**Outline Planning Application, Ribble Valley District
3/12/0179 land at Accrington Road, Whalley**

I have no objections in principle to this outline proposal on highway grounds. However, my comments refer to an Outline Planning Application with all matters reserved for future determination except for the means of access. This Application is for a development of up to 78 residential dwellings, incorporating 40 retirement flats and 38 bungalows for the over 55's on land adjacent to Accrington Road, Whalley.

The following comments relate to the Transport Assessment (dated December 2011) and prepared by PSA Design on behalf of Briery Homes. Lancashire County Council is responsible for providing and maintaining a safe and reliable highway network. With this in mind the present and proposed traffic systems have been considered in and around the area of the proposed development.

© Harrison & Pitt
Residential Units at Accrington Road
Whalley
for Briery Homes
PROPOSED SITE PLAN
1637-040 P4 1:500 @ A2

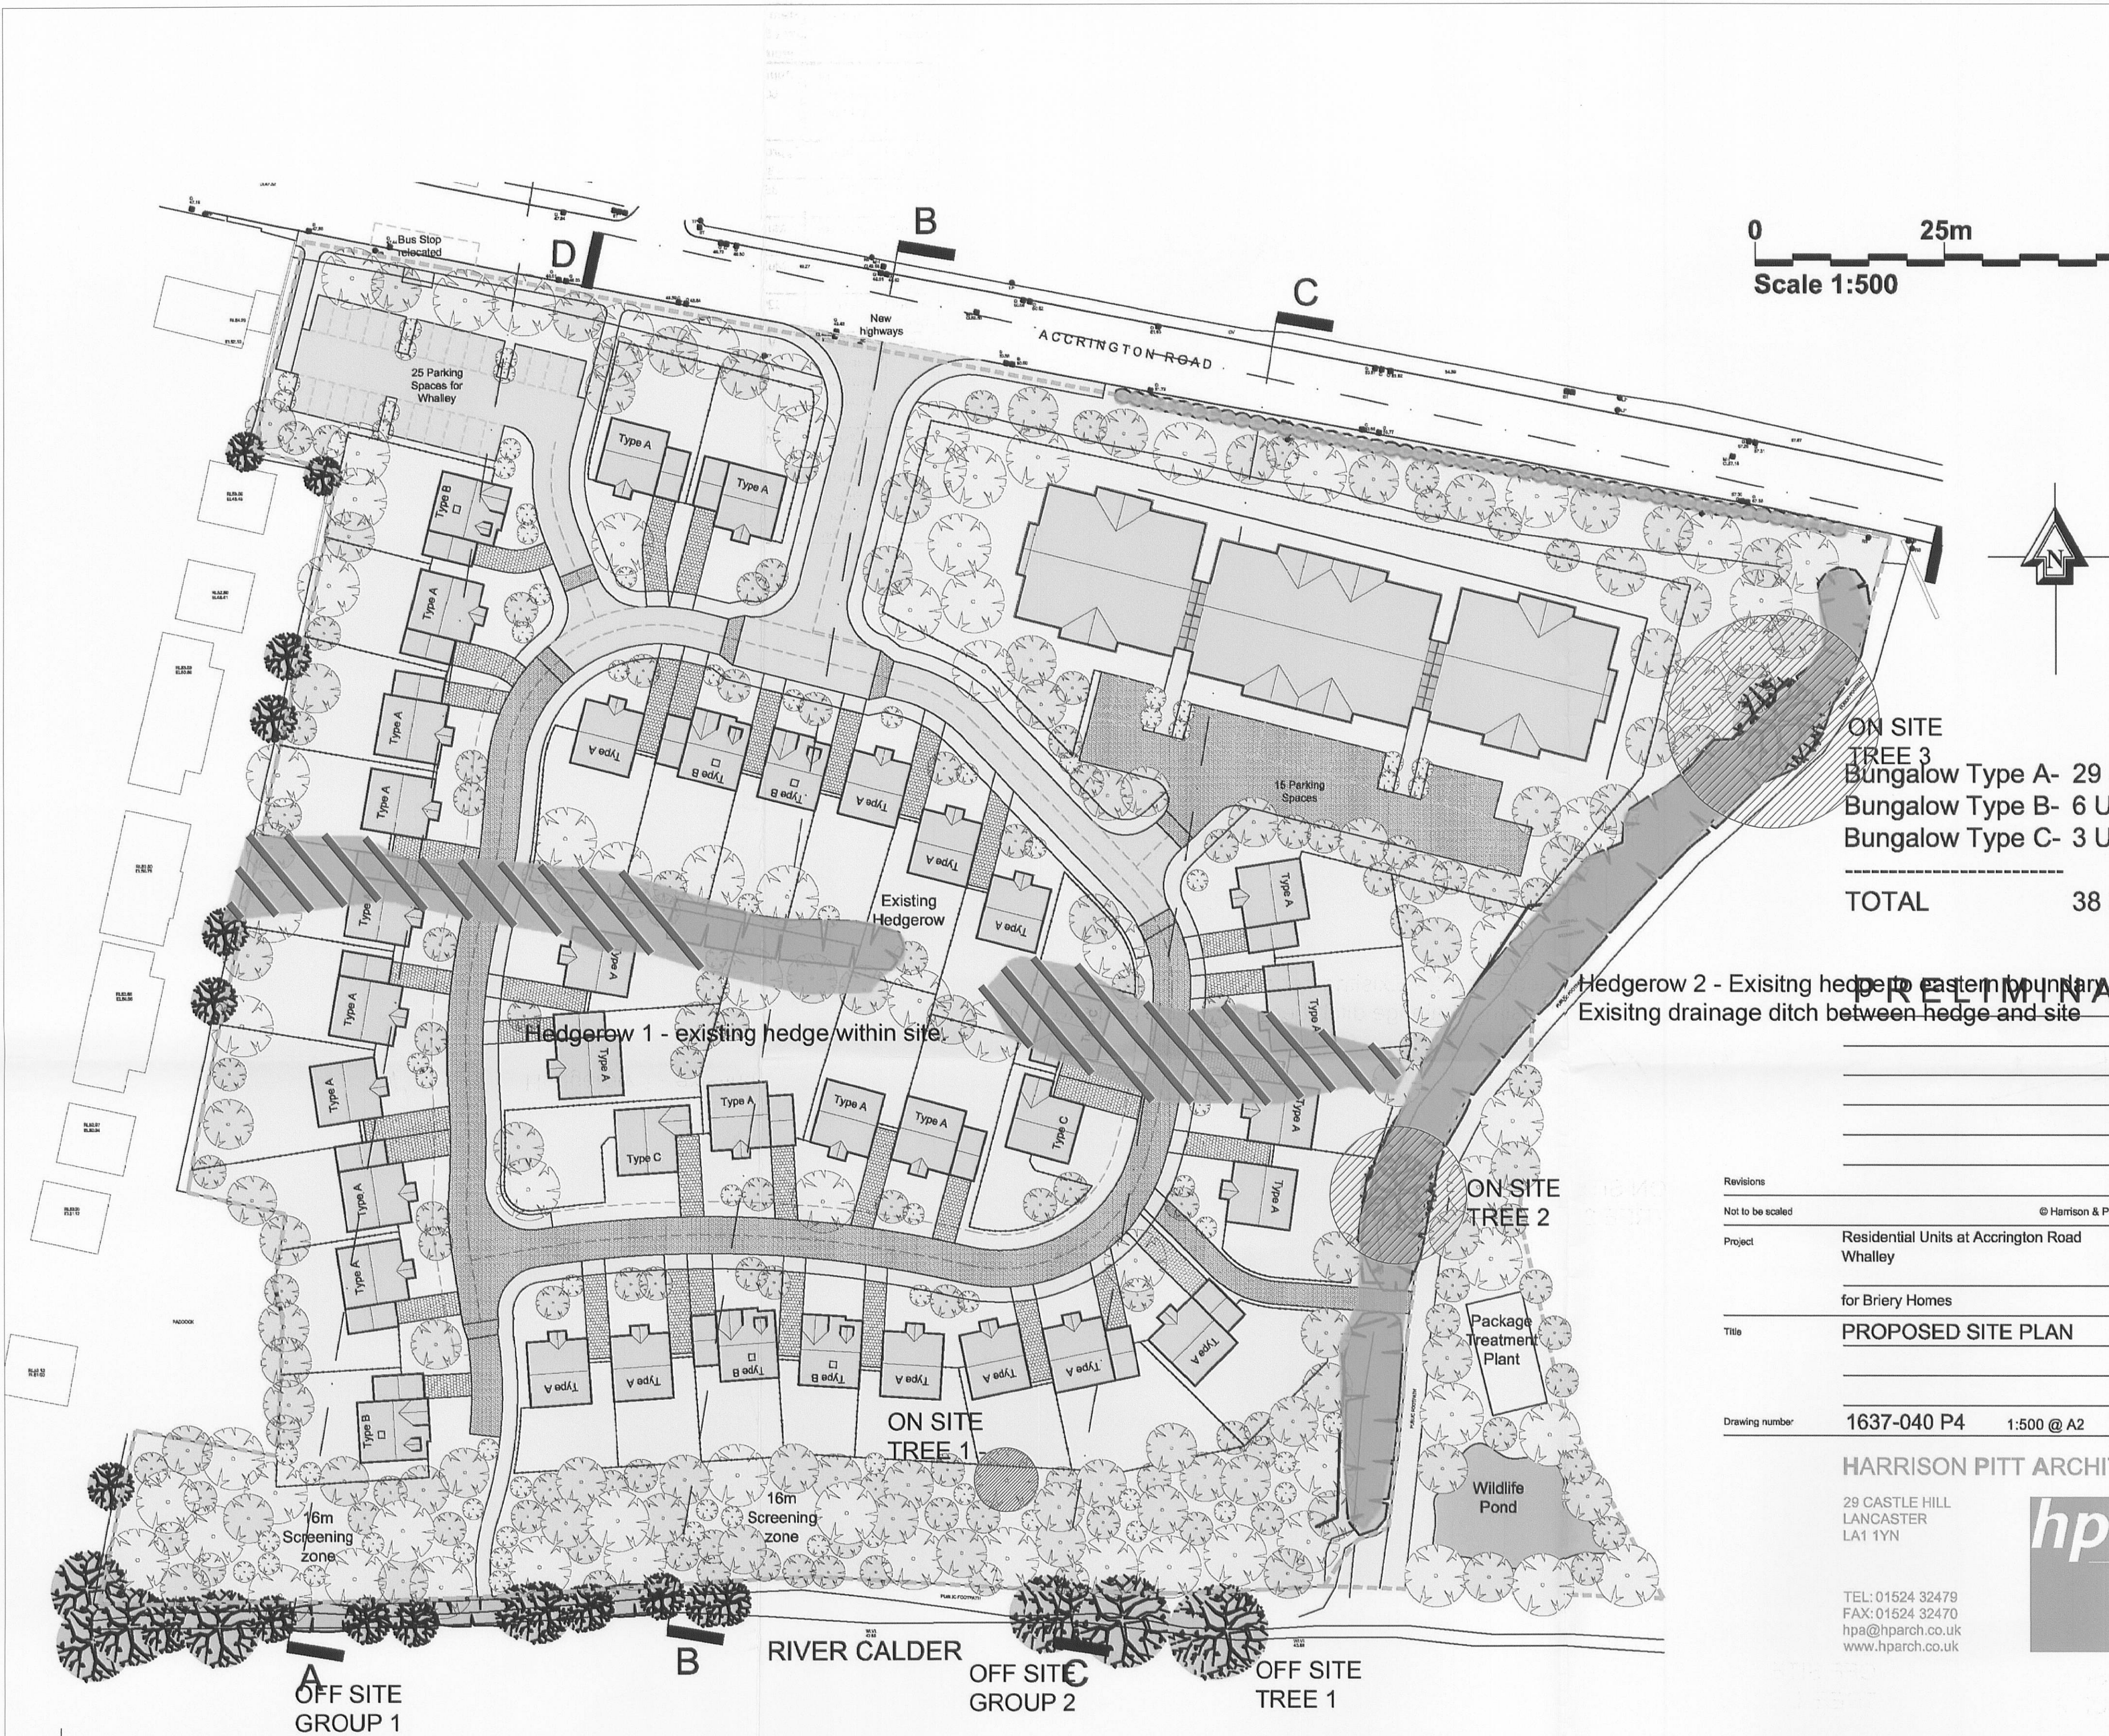
The vehicular access to the site will be formed from the site to Accrington Road. The design contained in Drawing 1637-040 P4 provides an acceptable range of highway parameters for the design of a suitable vehicular access.

It is indicated that there will be a short section of the access road where the gradient increases from the 1:20 that will form the majority of the road. While the gradient will not exceed 1:12 at any point, I would welcome a detailed breakdown of the relative gradients to insure that there are no inappropriate changes in level within the site.
